Rezoning Transportation Analysis
Petition Number: Insert Zoning Petition #2021-270
General Location Identifier: 10502126, 10502127

Date	Description
04-12-2022	First Review (AO)

Transportation Summary

**REZONING SITE PLAN**

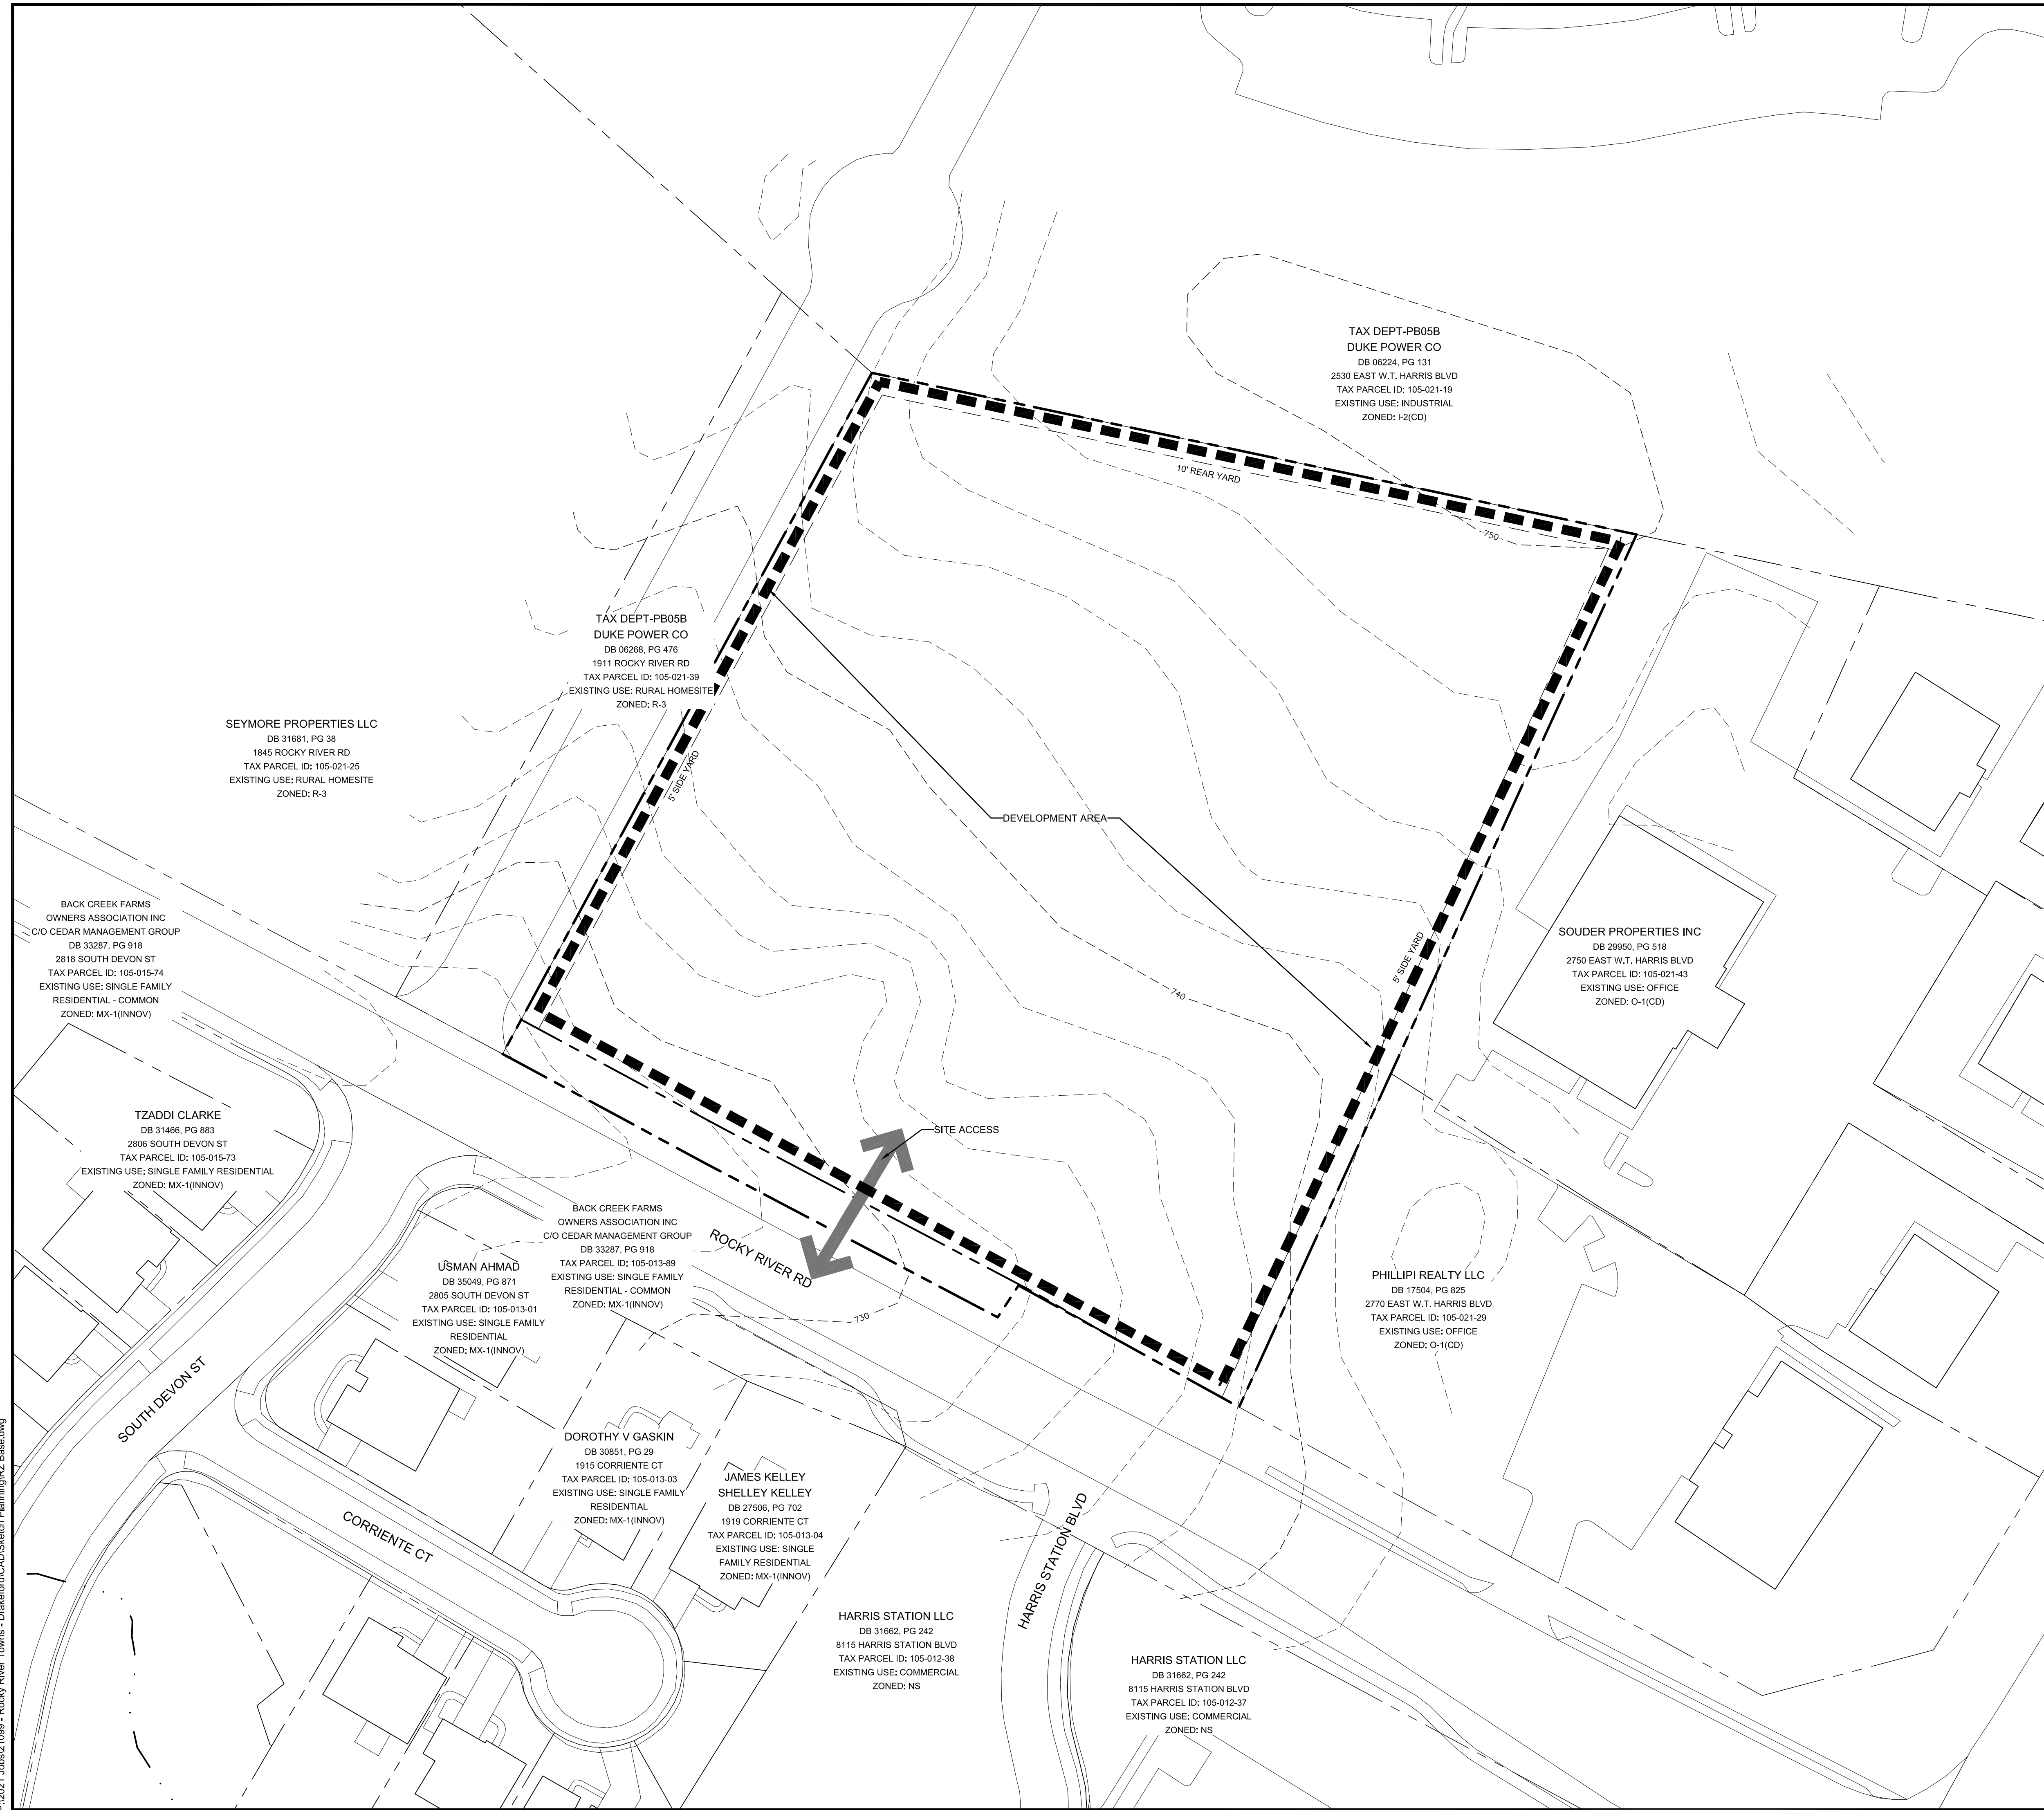
1. Curblin:

- a. **Rocky River Road:** Distance from centerline to back of curb: 19 feet

Label and dimension the curb and gutter from the centerline for each road on the site plan.

- 3. Revise site plan and conditional note(s) to commit to dedicate 35 feet right-of-way from the road centerline of Rocky River Road. The site plan shall label and dimension the right-of-way from the road centerline.

- 4. Revise site plan and conditional note(s) to commit to construct an 8-foot planting strip, and 6-foot sidewalk on proposed private street per Chapter 19 / Chapter 20 and commit to constructing bicycle facilities by locating the curb and gutter 19 feet from the center line of Rocky River Road and installing an 8-foot planting strip and 12-foot multi-use path along Rocky River Road to meet the City Charlotte BIKE Policy.

The site plan shall label and dimension both items from the back of curb and gutter.

- 5. Revise site plan and conditional note(s) to show site access off Rocky River Road at Harris Station Boulevard instead of current proposed location.

- 6. Revise site plan and conditional note(s) to commit to constructing a left-turn lane into the site off Rocky River Road, creating a 3-lane section along the site frontage. These improvements will be coordinated and approved by NCDOT.

- 7. Revise site plan to label all proposed streets and alleys as public or private and provide CLDSM detail/typical section.
- 8. A site plan note(s) specifying dedication and fee simple conveyance of all rights-of-way to the City before the site's first building certificate of occupancy is issued as needed. CDOT requests rights-of-way set at 2' behind back of sidewalk where feasible.
